City of Sydney

26 October 2011

RE: Section 75W request to modify the approved Project Application for Block 2 at Central Park, 26 Broadway, Chippendale (MP09_0078 MOD 3)

1 SECTION DETAIL - AWNING / GREENWALL INTERFACE
1 : 10

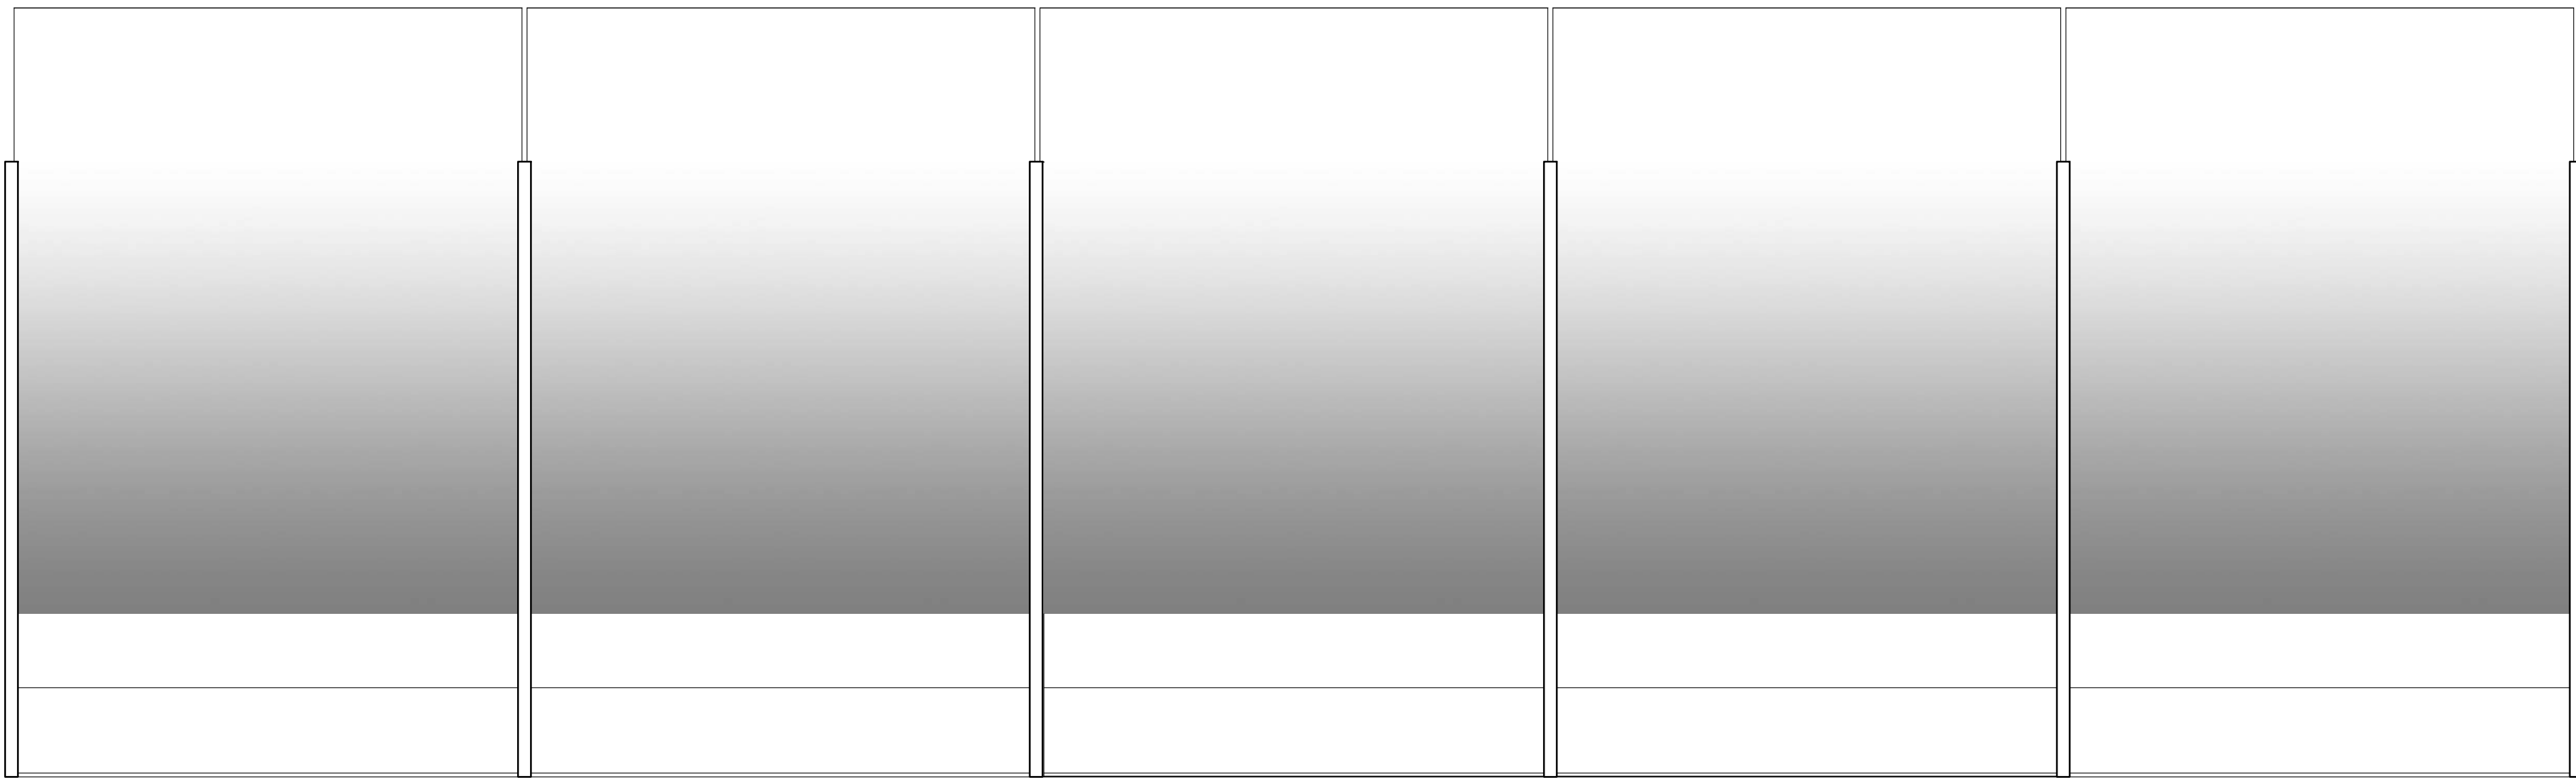
The City has previously raised concern as to ongoing maintenance of the green wall. The Proponent must ensure that the design intent of the original planting scheme is realised and sustained over the life of the building.
